LAND AT SALT BOX, BOGNOR REGIS

INDEPENDENT REVIEW OF SURFACE WATER SYSTEM

Date: 28 October 2021

Doc ref: SAL-HYD-R-C-GLOS-0001

B

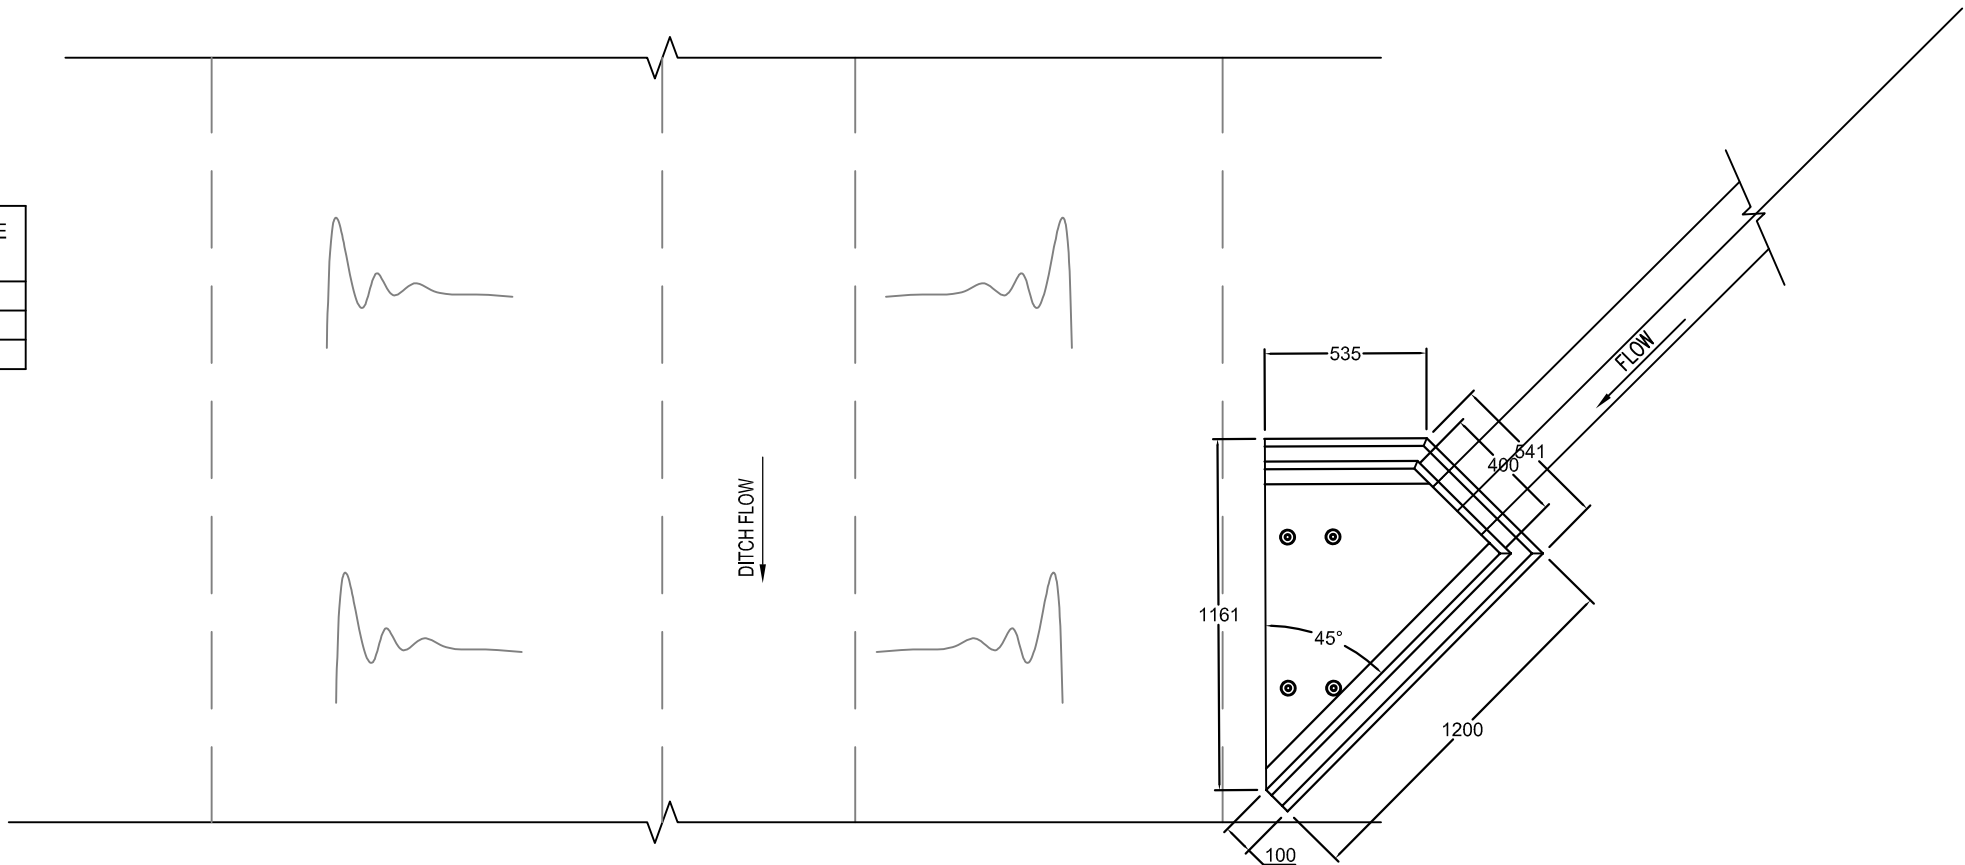
The Environmental Agency (EA) submitted approval permits for the 2 no. headwalls on the 9th February 2021. This permit includes the changes made to the headwall design on Hydrock's layouts and details on the 17th December 2020 from a 90 to 45-degree splayed headwall. This change was requested by Annabelle Kendall of the EA on the 20th November 2020. The reason for the change was to avoid erosion of the opposite embankment, thus negating the need for erosion matting.

This arrangement also allows for easier construction and prevents the need for slow bends into the headwall where it would instead have been repositioned at an angle, thus providing a better system with less maintenance. The headwall used is of same material as designed, provided by Althon, a reputable national supplier of headwalls. I see no issues with the change in design as it is a more beneficial arrangement.

SAL-HYD-PH1-ZZ-DR-C-7010

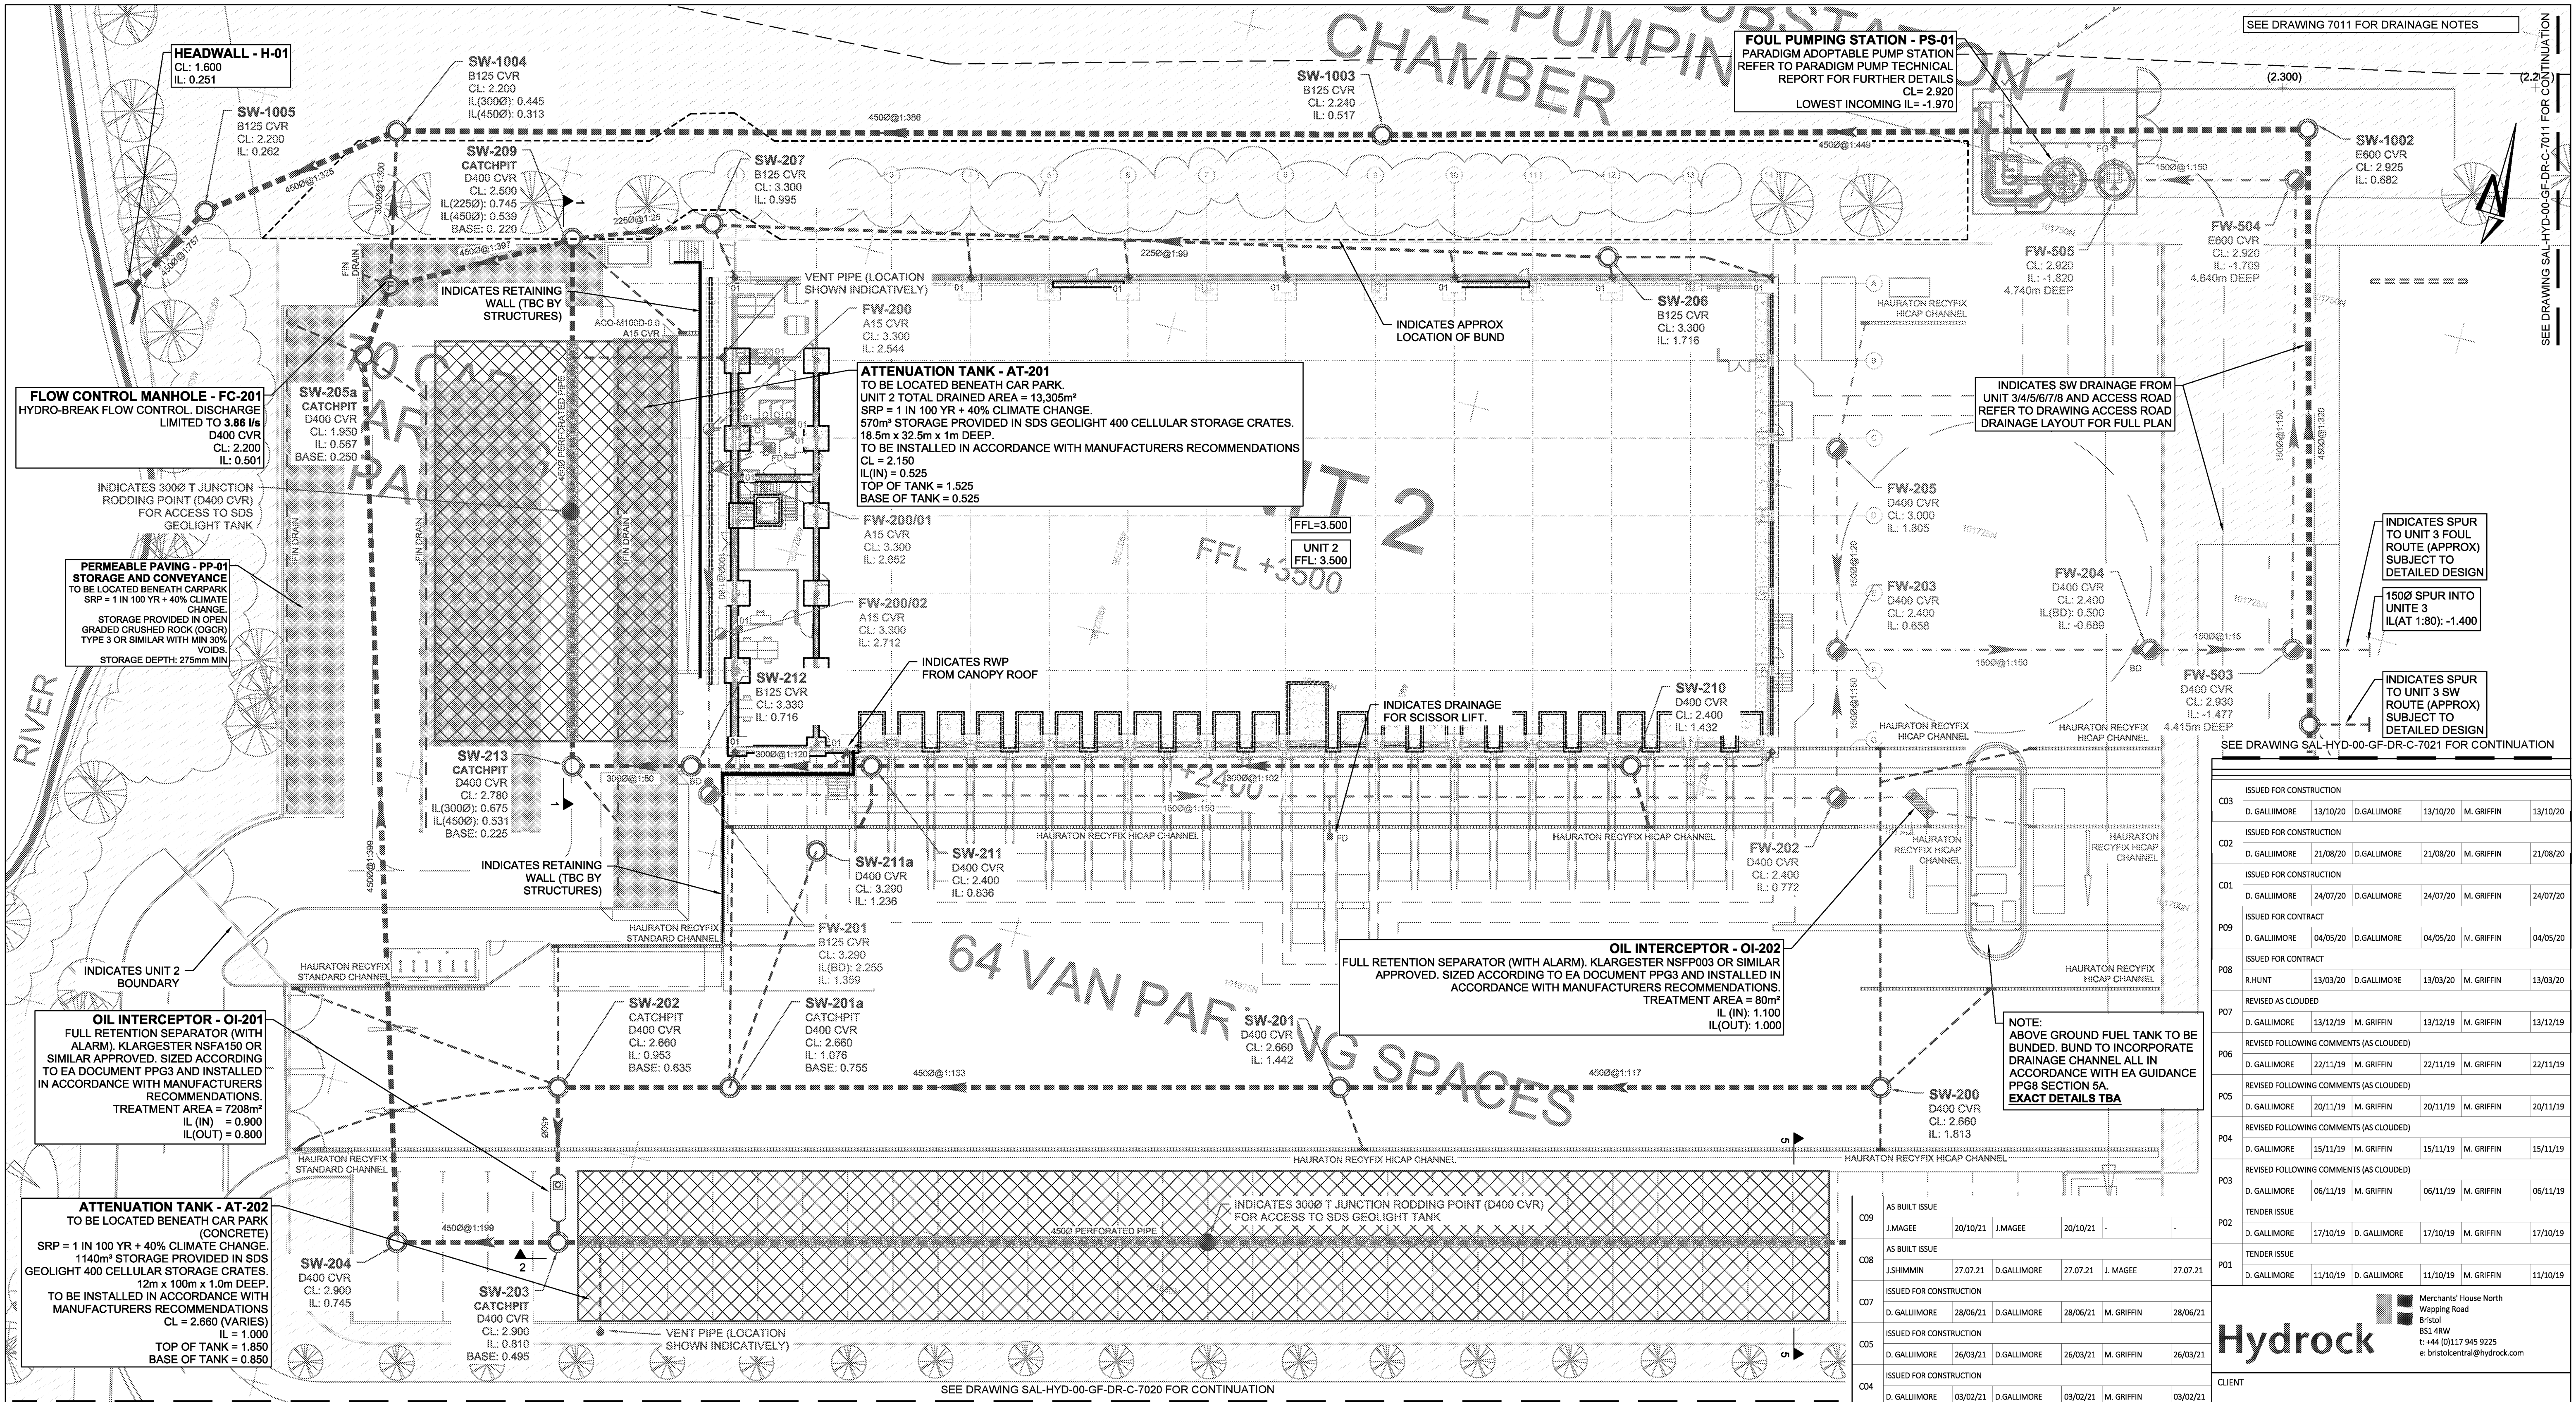
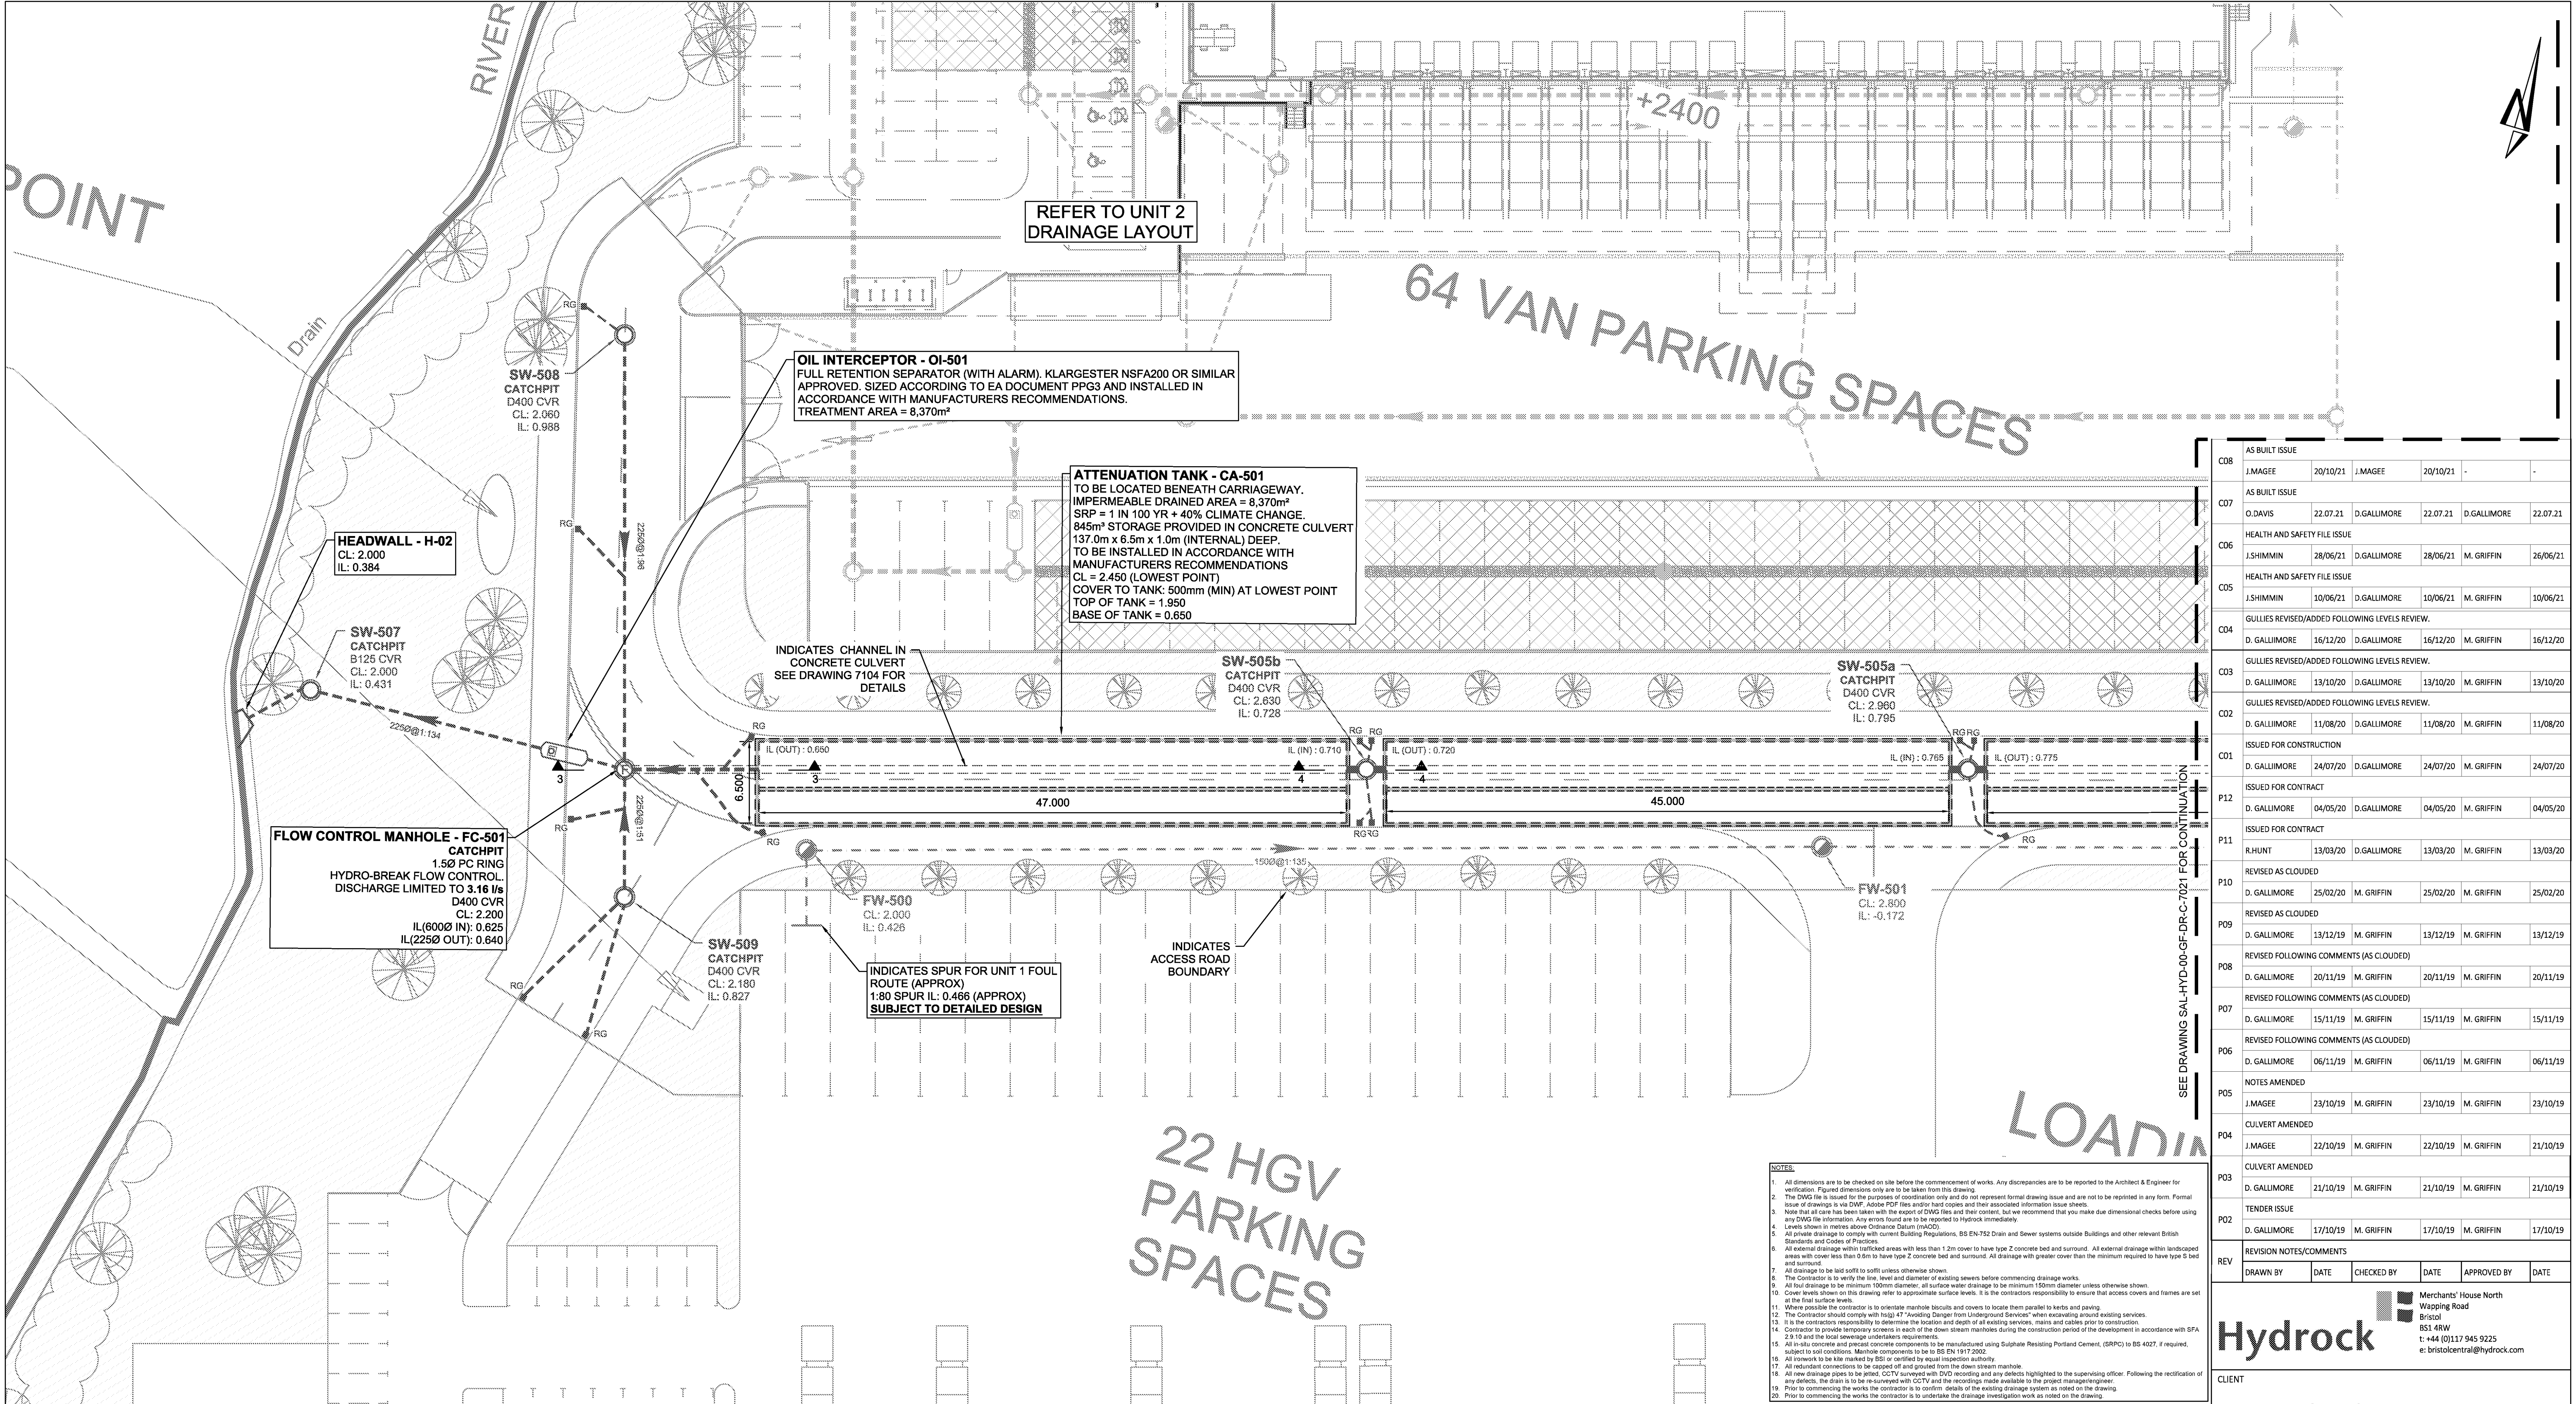
1. The majority of pipe falls are inaccurate
2. SW 209 manhole position and incoming pipes
3. SW 211a not shown on Hydrock Drawing
4. Review and check pipe and tank fall SW 213 (8mm backfall)

1. The majority of pipe falls are inaccurate
 - a. Updated to suit level change summary and ADBLY PDF. *[Refer to Appendix L]*
2. SW 209 manhole position and incoming pipes

- a. Updated to suit. *[Refer to Appendix L]*
3. SW 211a not shown on Hydrock Drawing.
 - a. Added to drawing 7010. *[Refer to Appendix L]*
4. Review and check pipe and tank fall SW 213
